# MDT-SF21026-R5-CDs.pdf Markup Summary

RD13

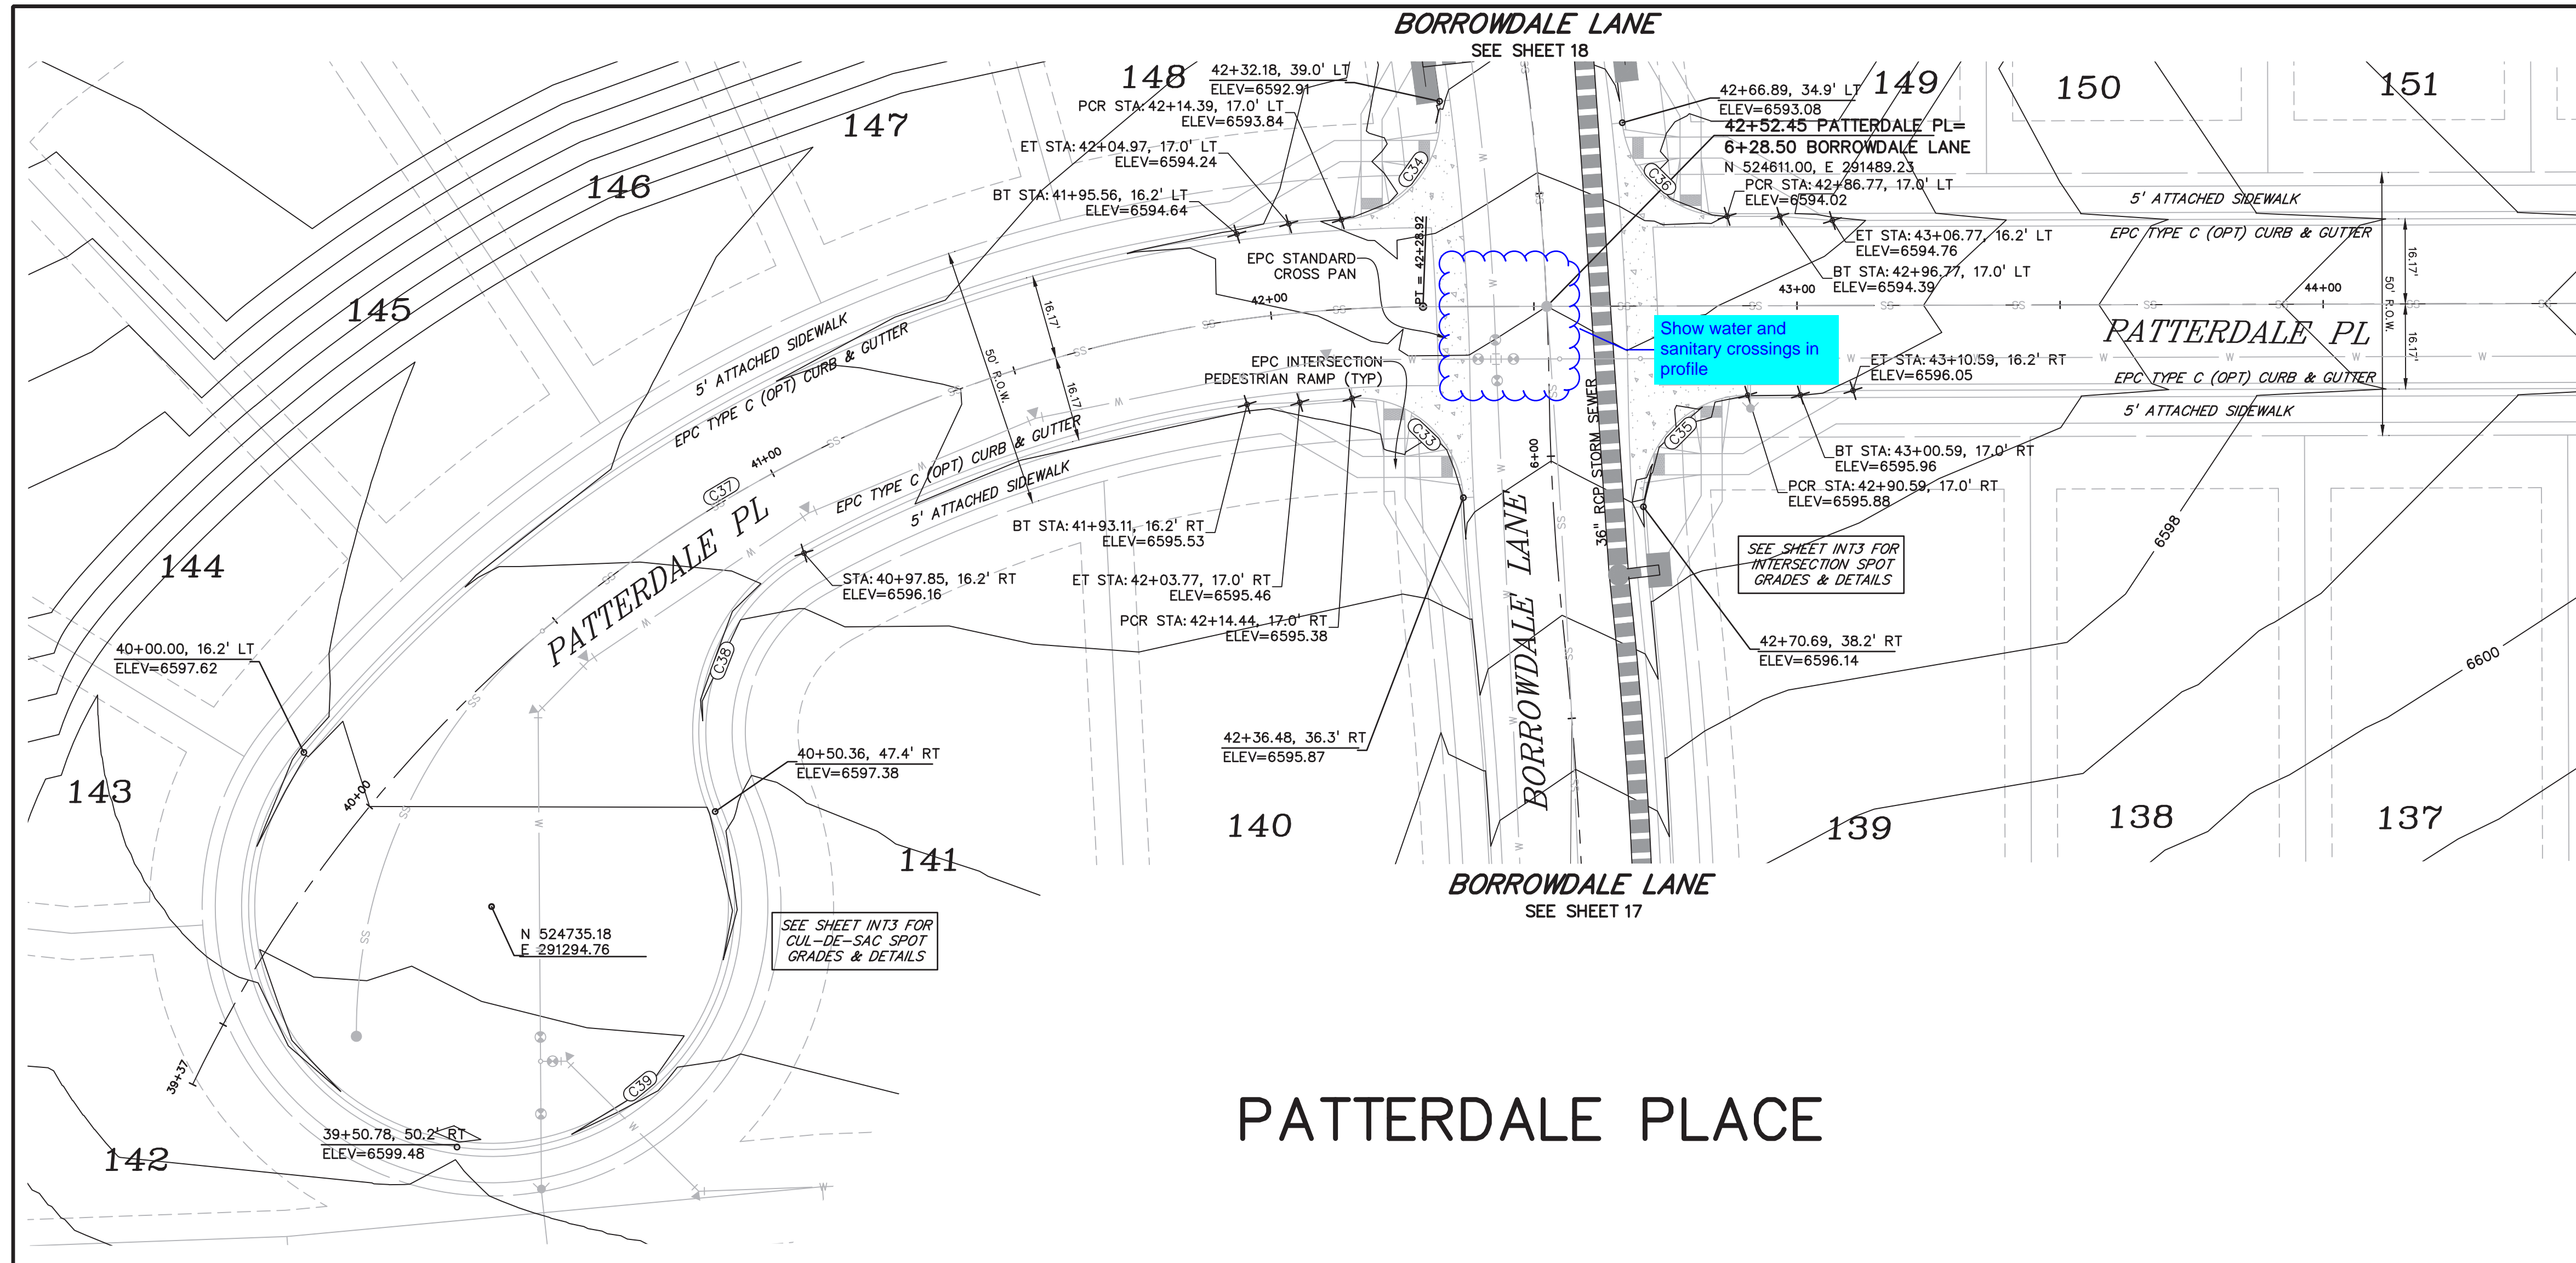
Verify that this is the depth at the pipe (accounting for cross-slope)

may need to be 6'

Street is warped at this intersection, so cover is still over 2'

Manhole sizing updated

**RD13**

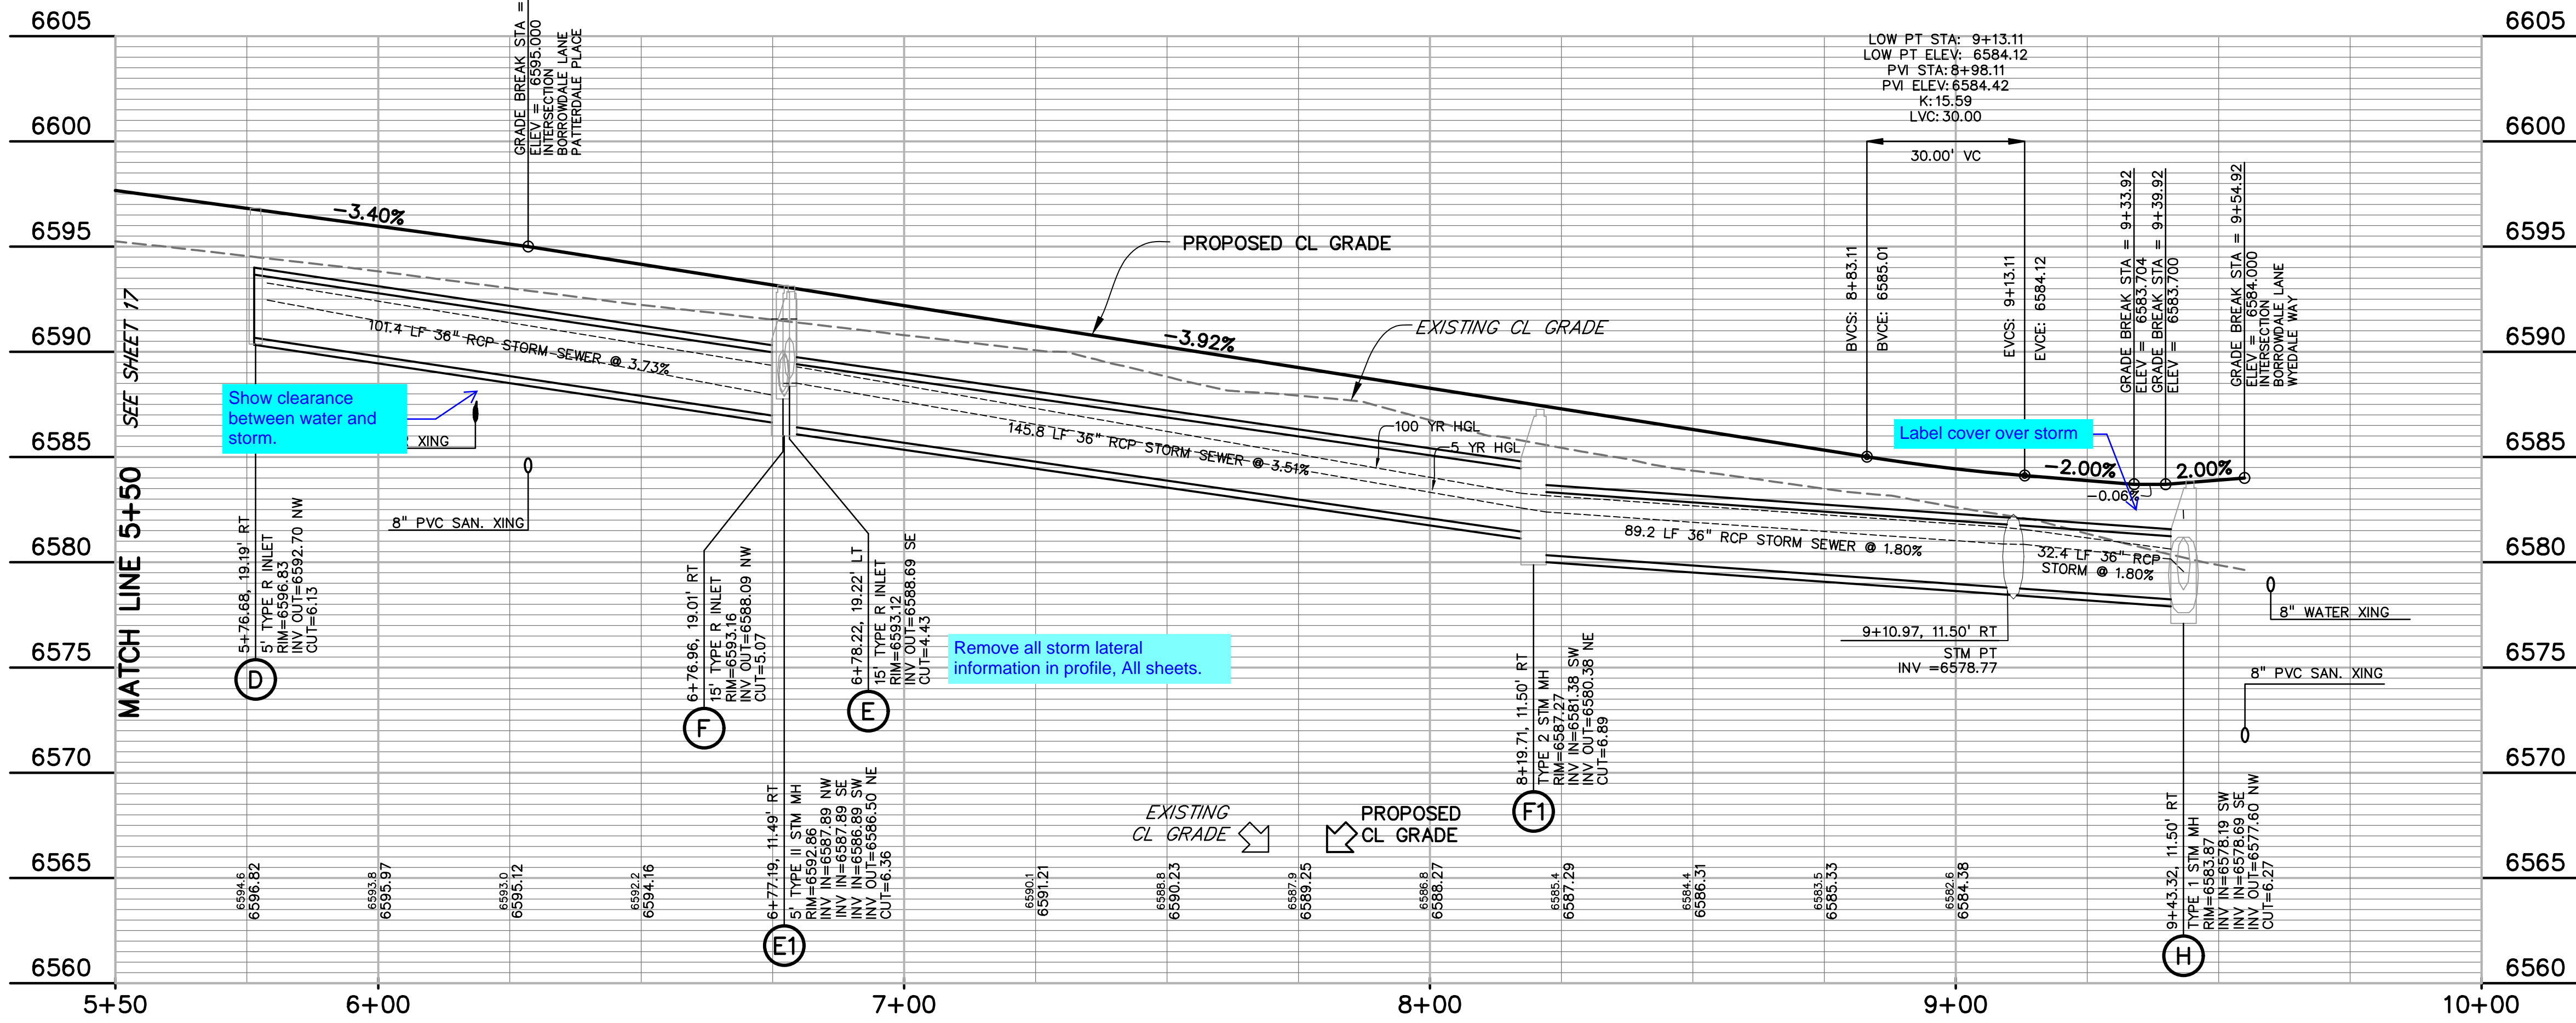
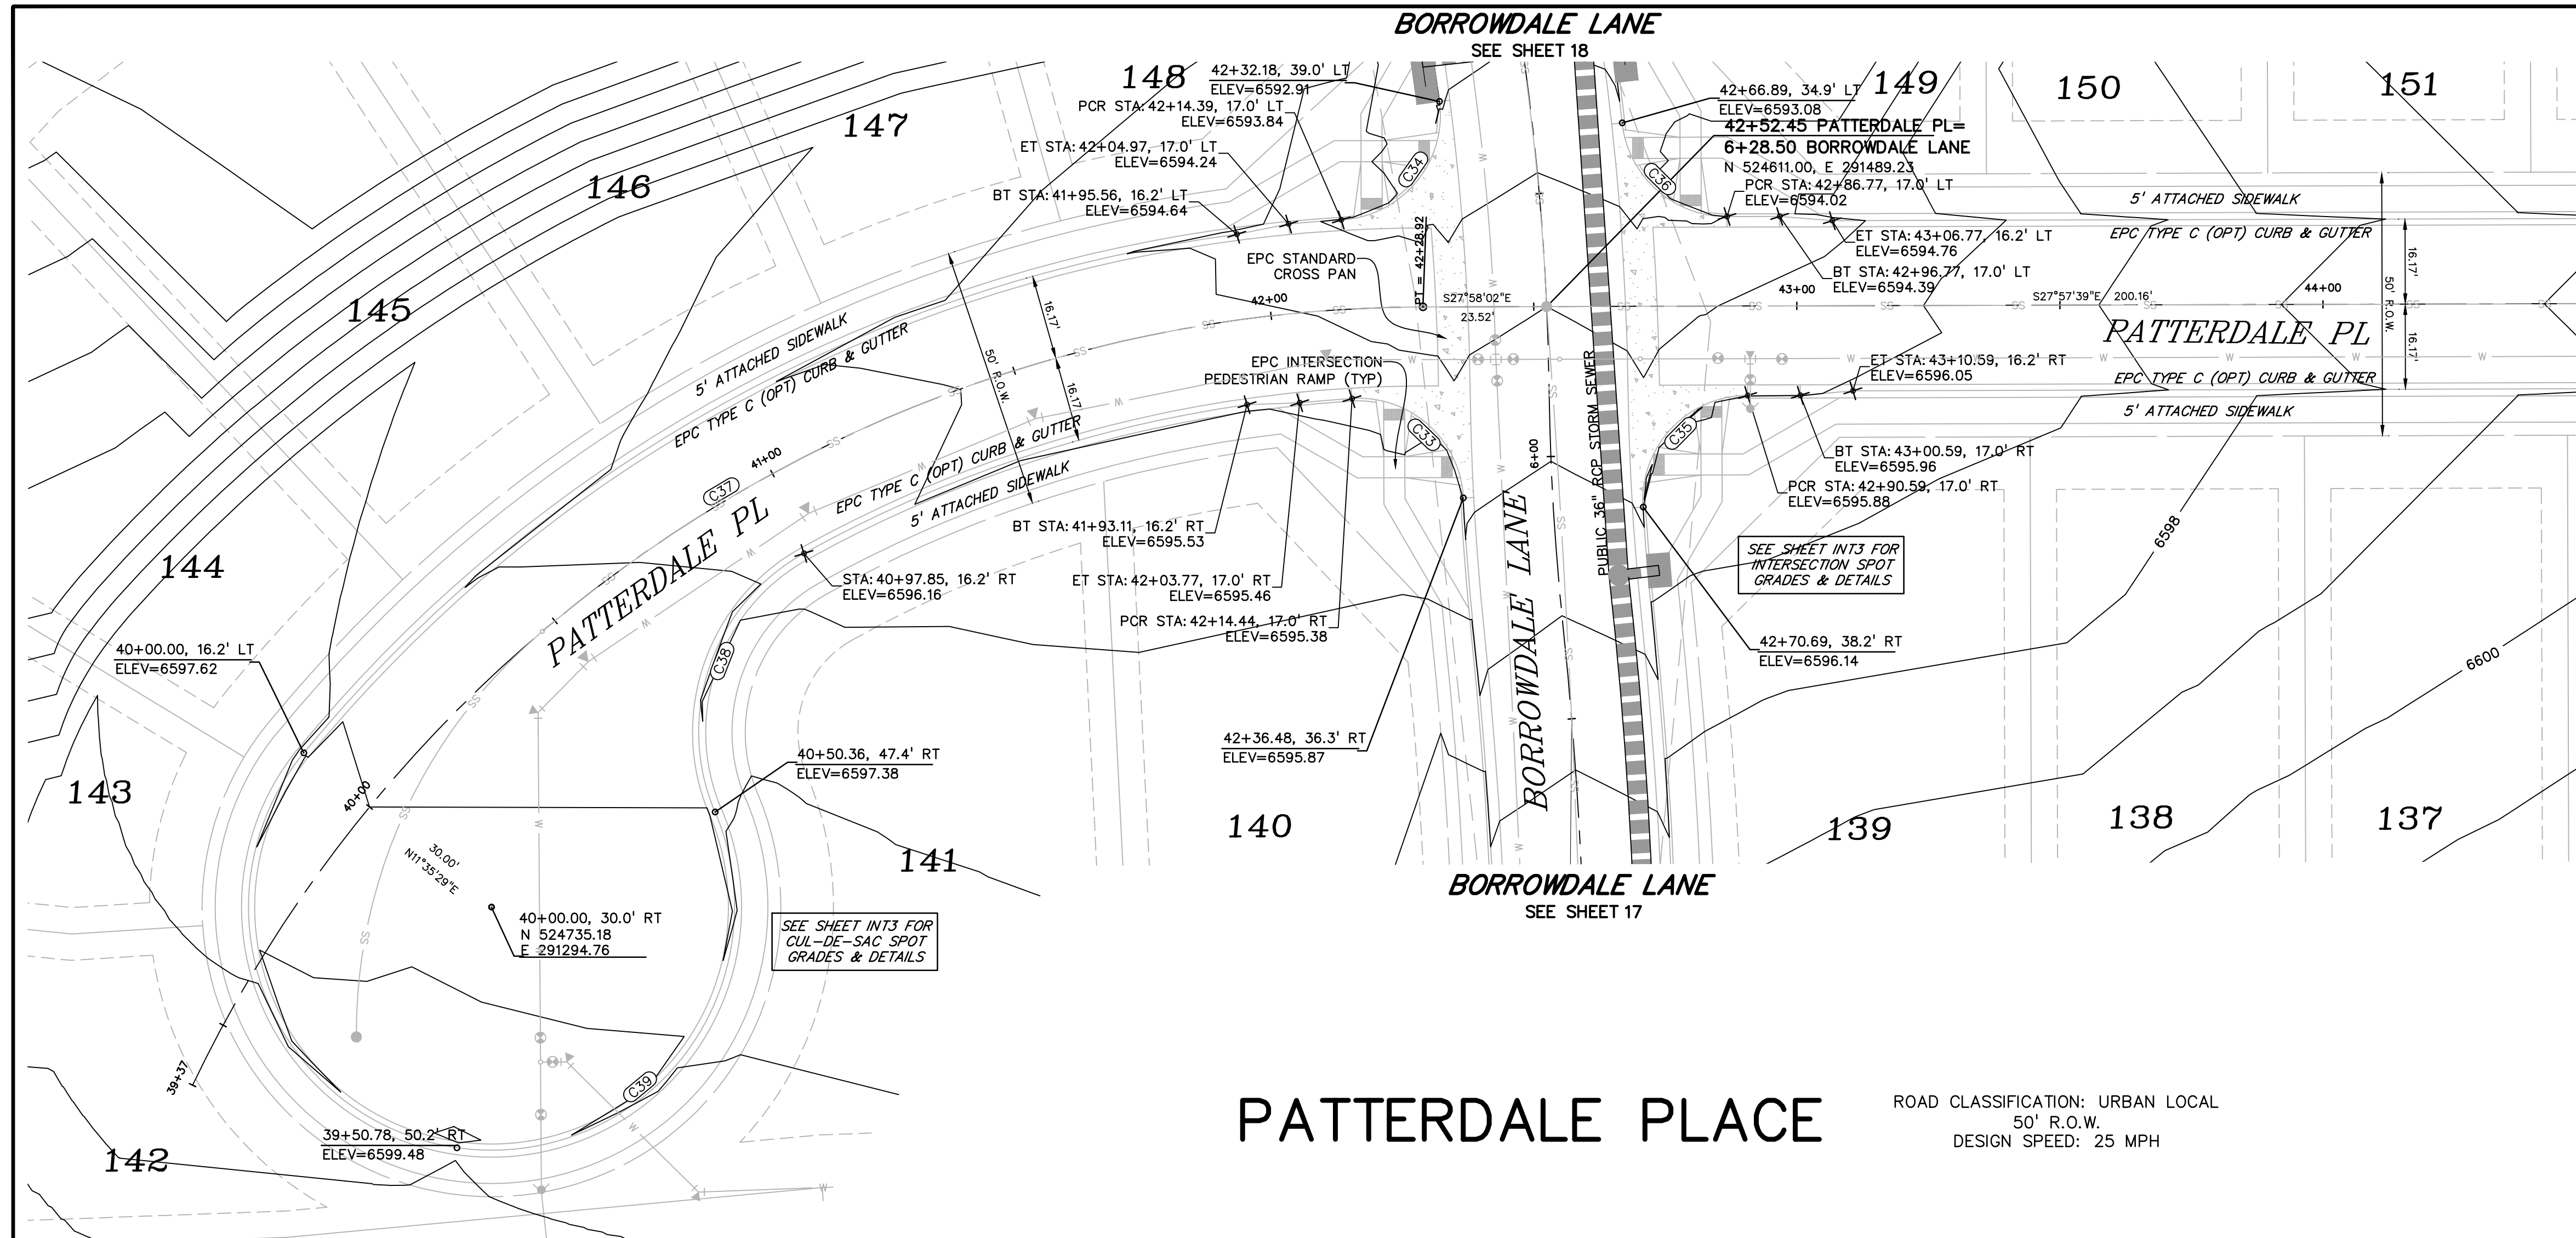
**Subject:** Callout  
**Page Index:** 18  
**Date:** 3/2/2022 4:30:46 PM  
**Author:** dsdrice  
**Color:** ■  
**Layer:**  
**Space:**  
**Page Label:** [18] 18 RD13

**Subject:** Callout  
**Page Index:** 18  
**Date:** 3/2/2022 4:33:08 PM  
**Author:** dsdrice  
**Color:** ■  
**Layer:**  
**Space:**  
**Page Label:** [18] 18 RD13
